ADDENDUM # 1

PROJECT: Fore River Short Stay Hospital, Portland, Maine

PROJECT NO: 05-4898

DATE: November 22, 2006

Project Number  
 F05-4898  
 Drawing Title and Number  
 ELECTRICAL  
 FIRE ALARM  
 RISER  
 E4-2

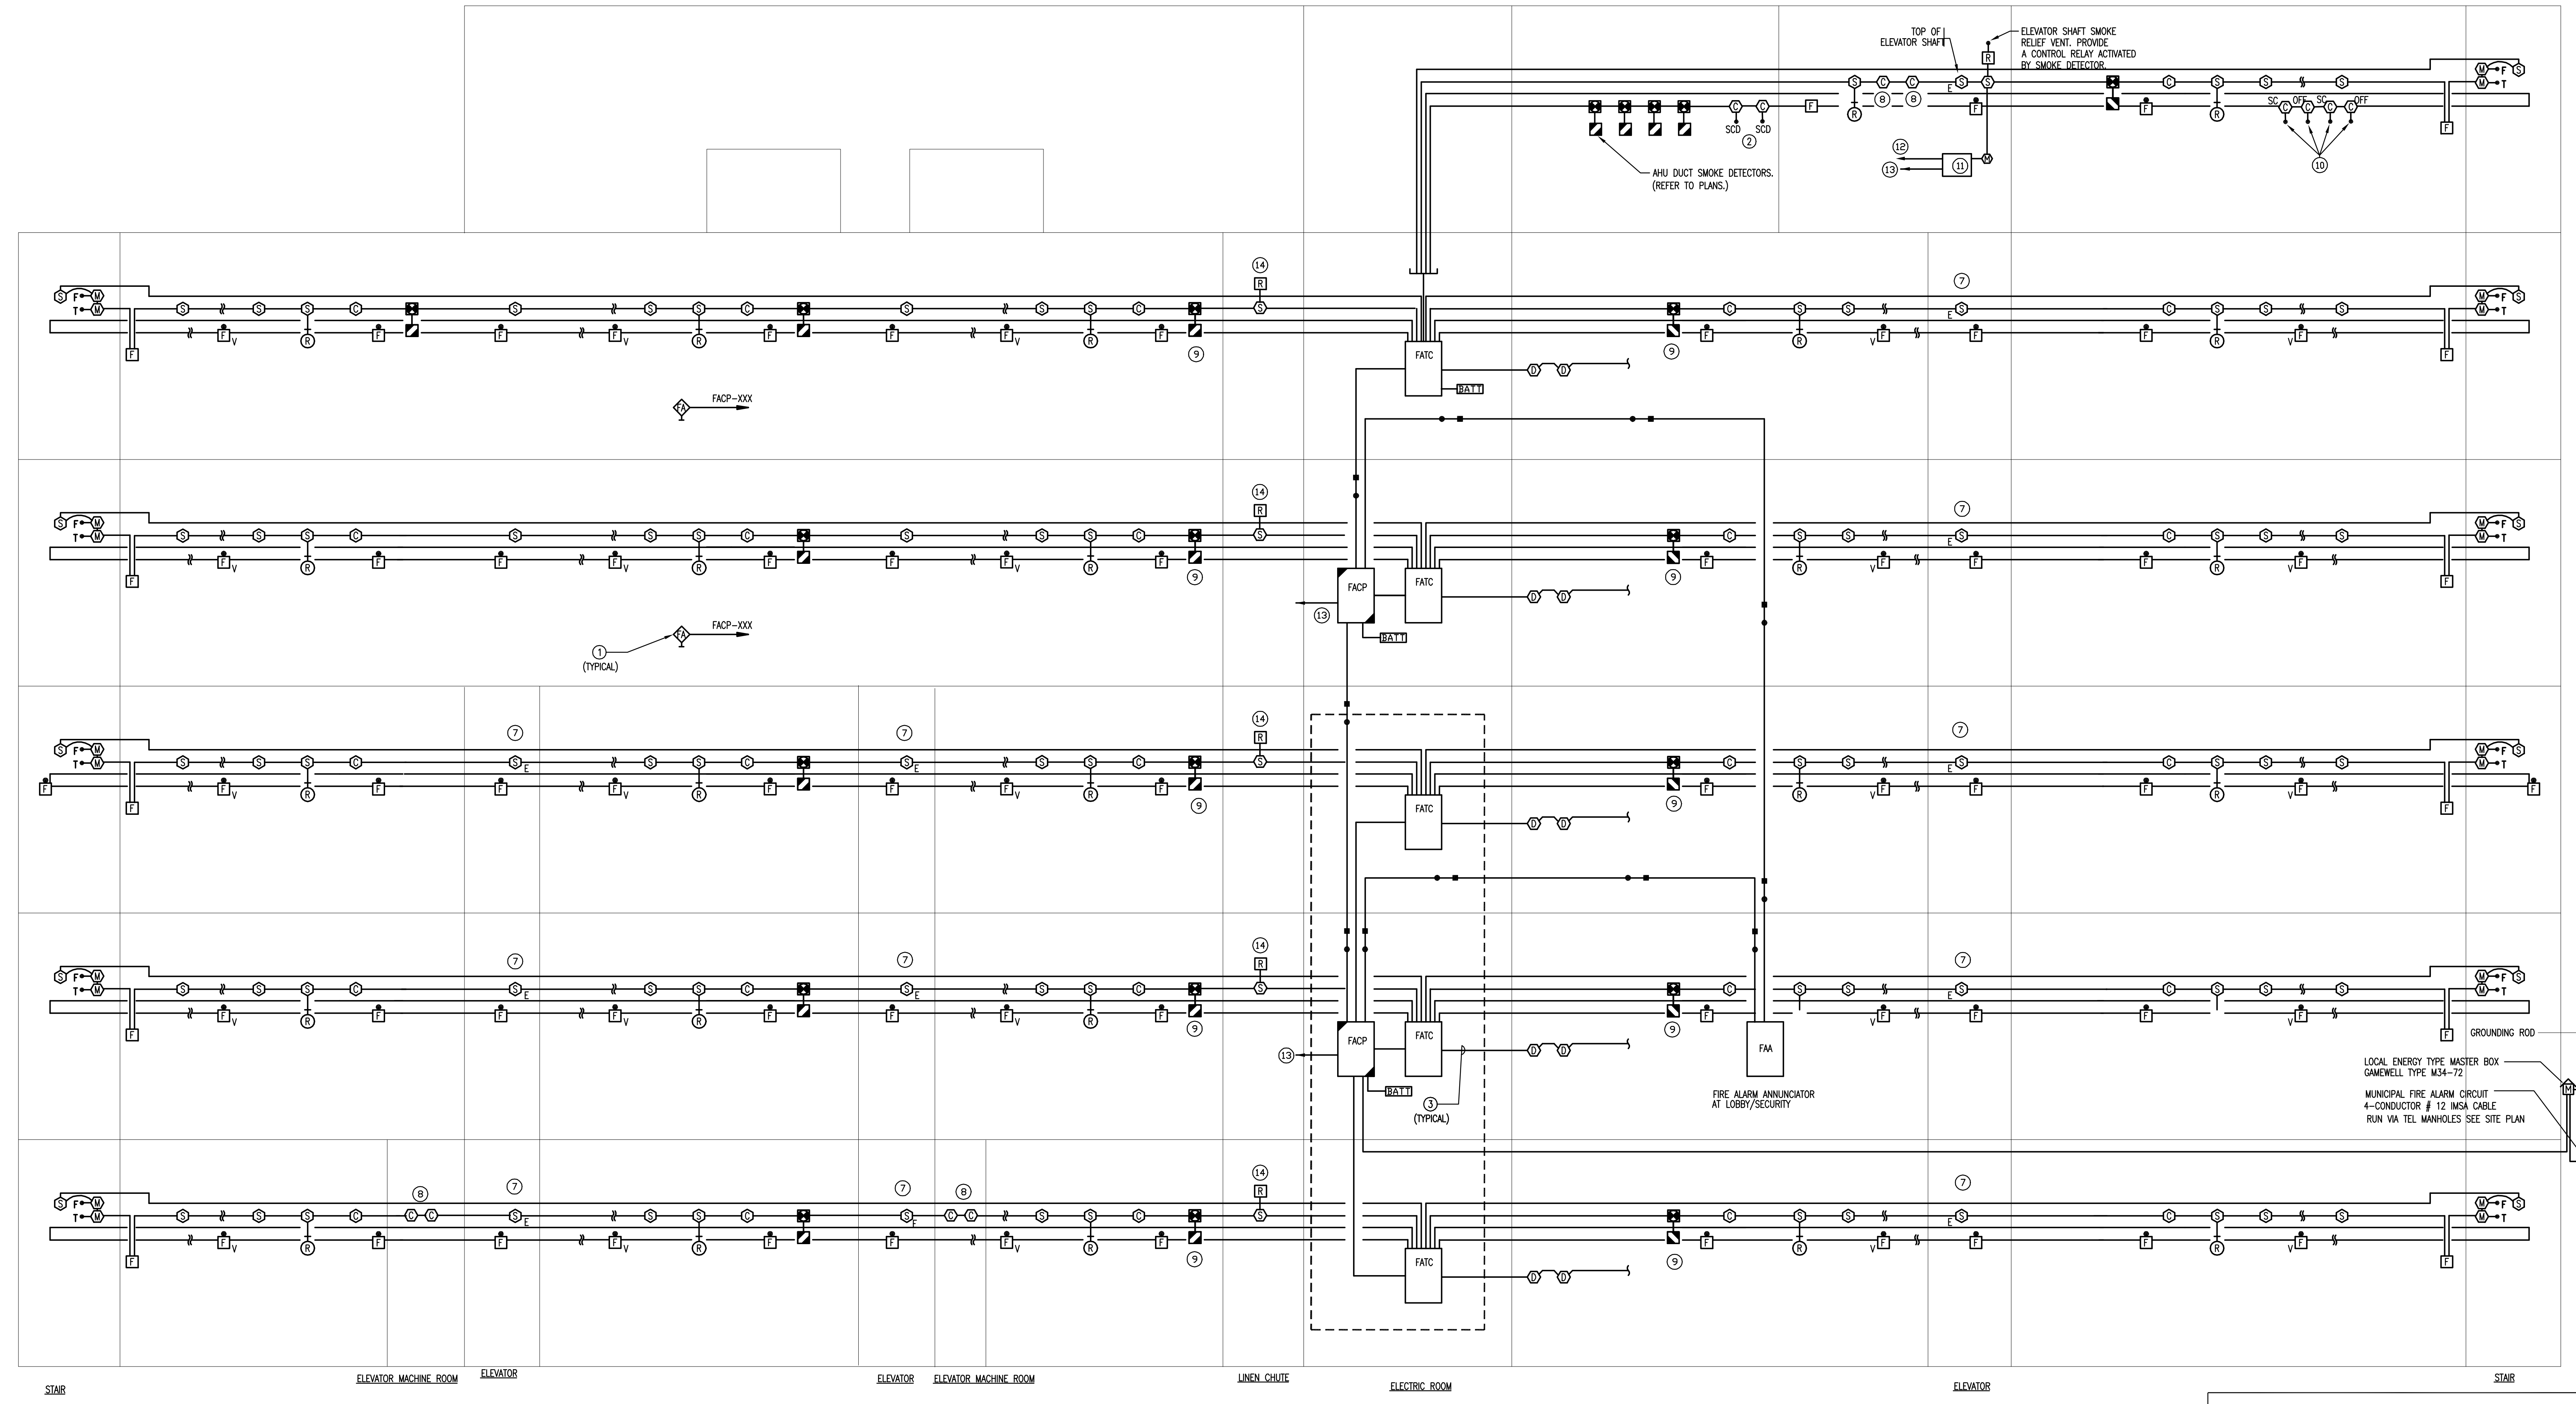
- L. Drawing E4-2
1. Added circuits for fire alarm control panels. Revised master box location.
- M. Drawing E5-2
1. Added feed for dimming cabinet.
 2. Revised feed for kitchen Item #32.

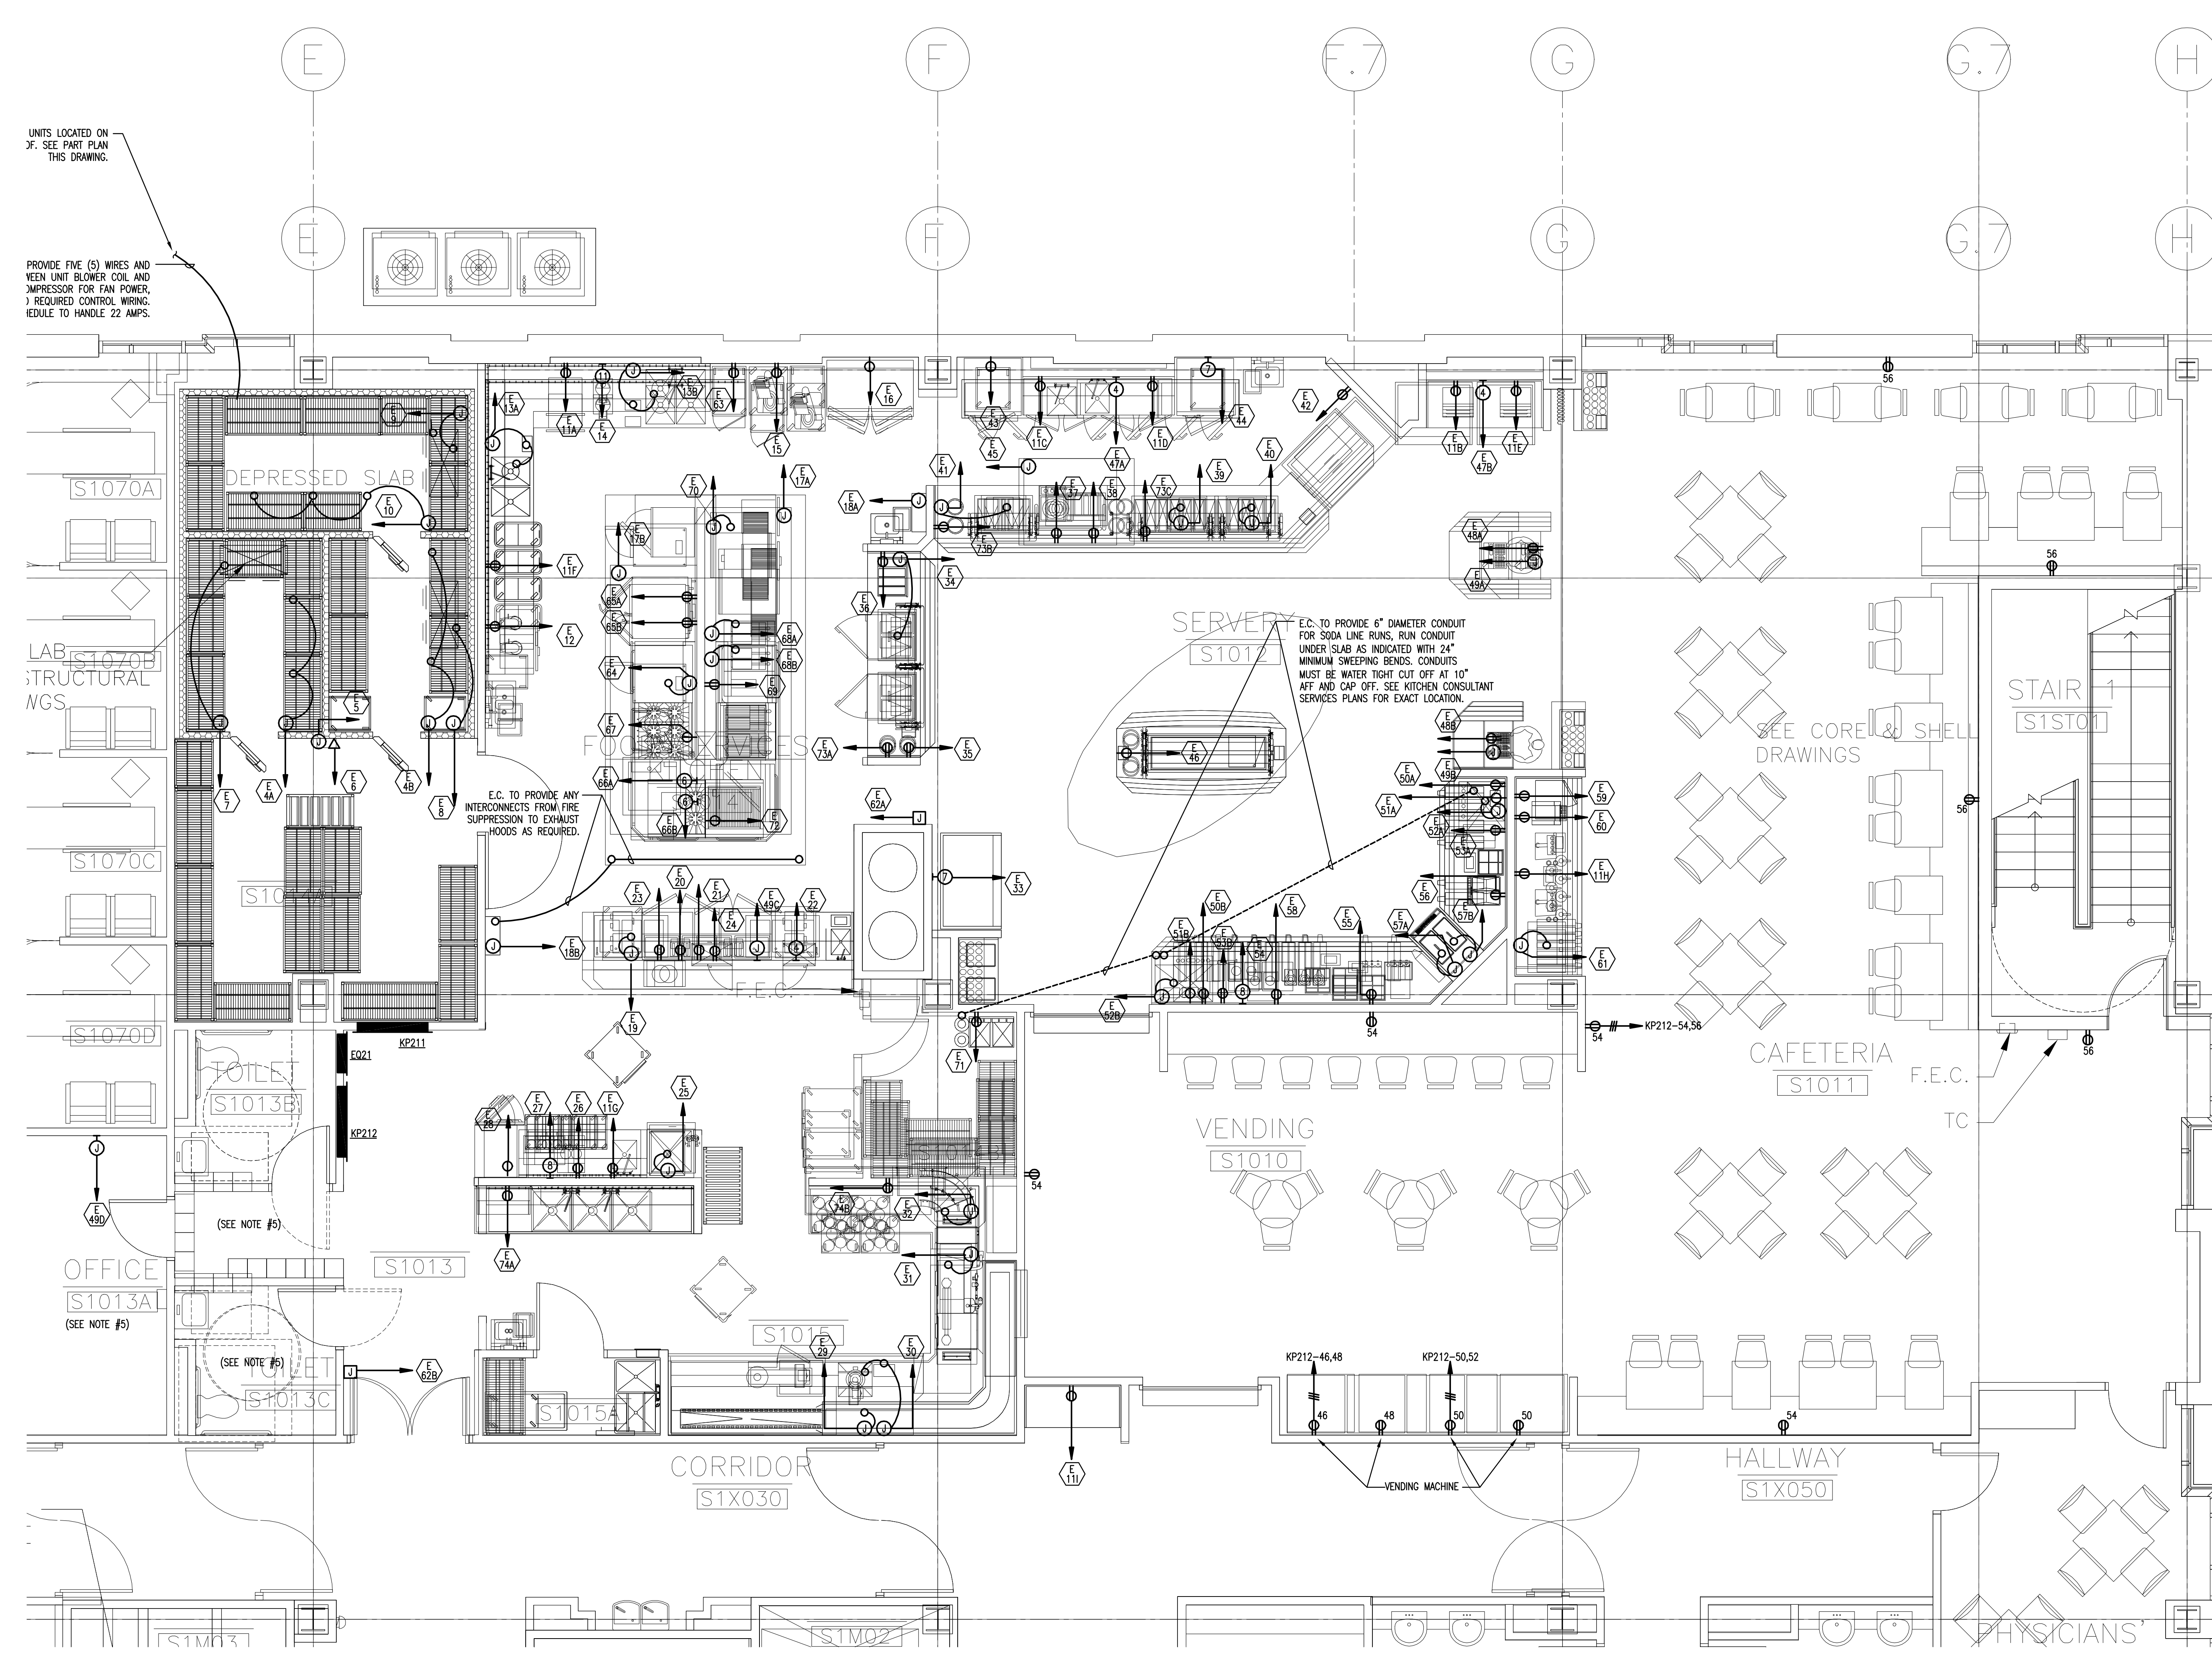
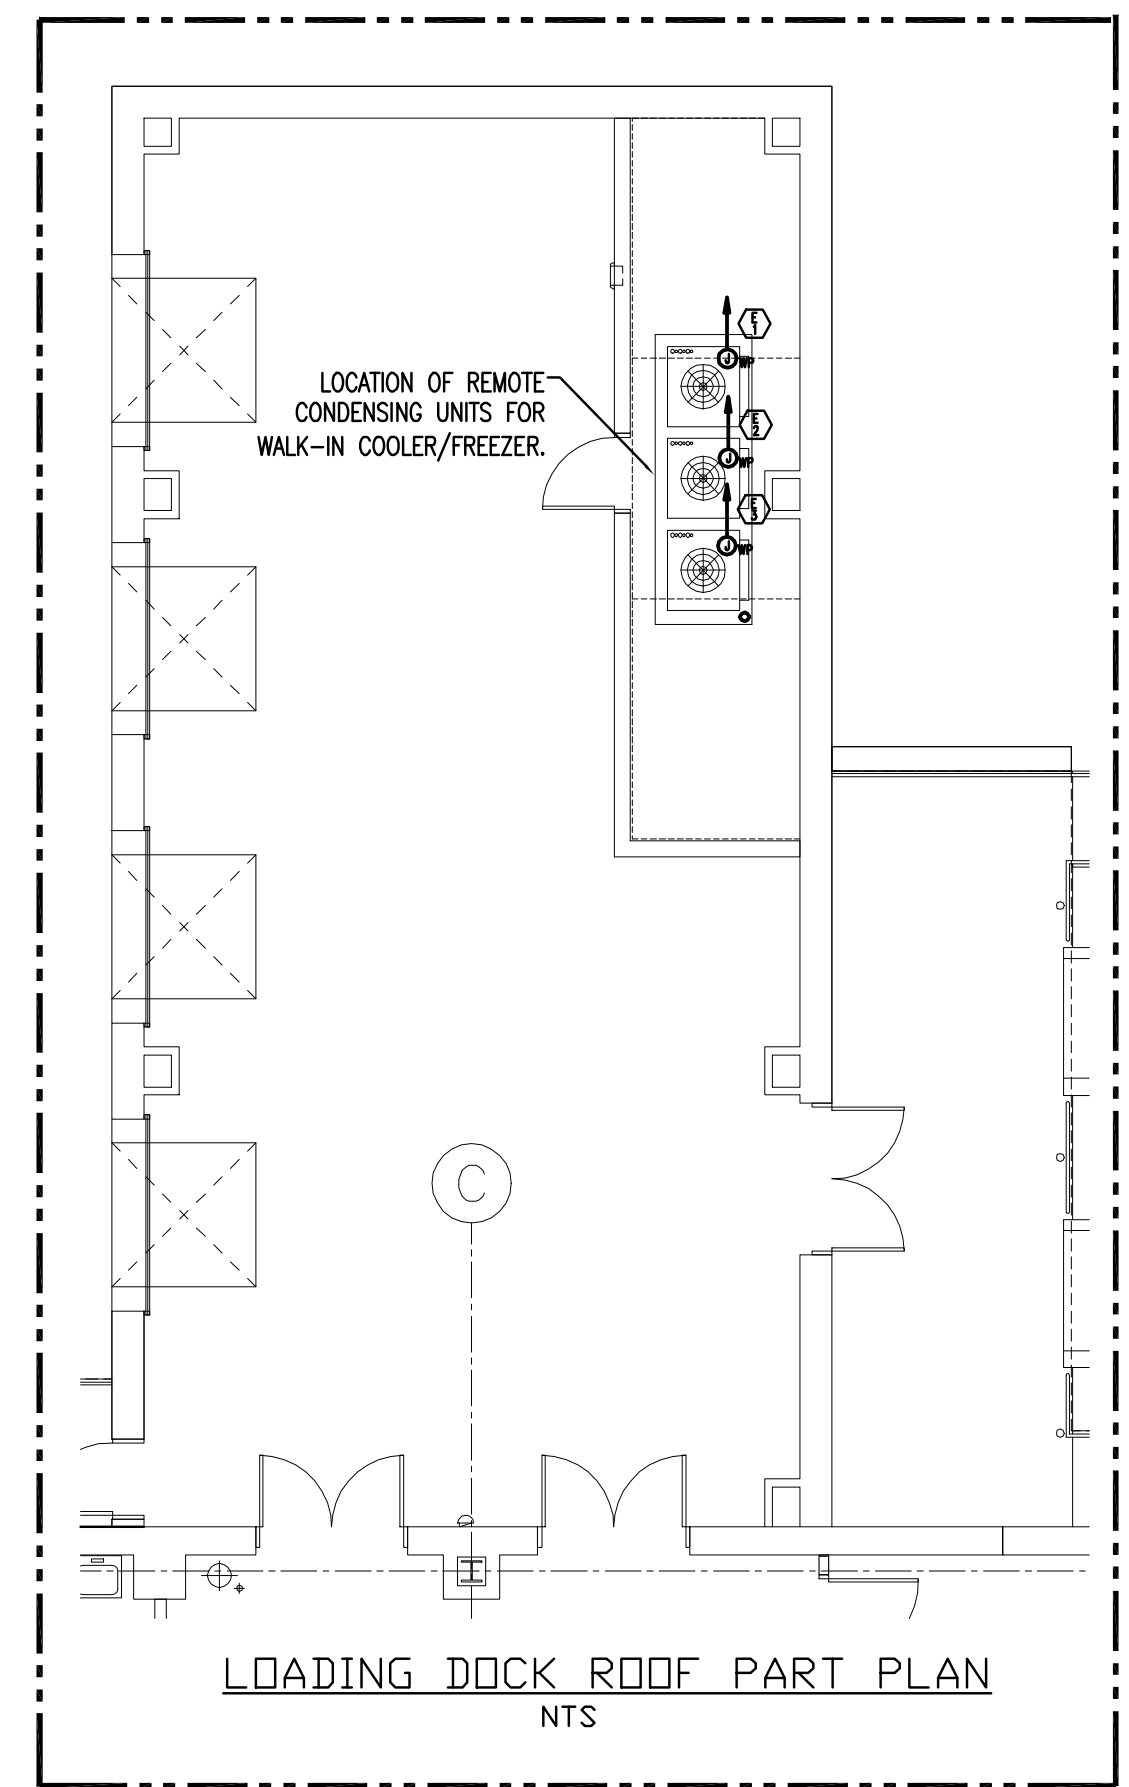
- C. Drawing E1-1
1. Added connection for (1) added disposal. Miscellaneous coordination items and circuiting.
- D. Drawing E1-2
1. Clarification to OR-6 and OR-2 panel labels. Revised emergency electric closet layout. Added connections for (2) added disposals. Miscellaneous coordination items.
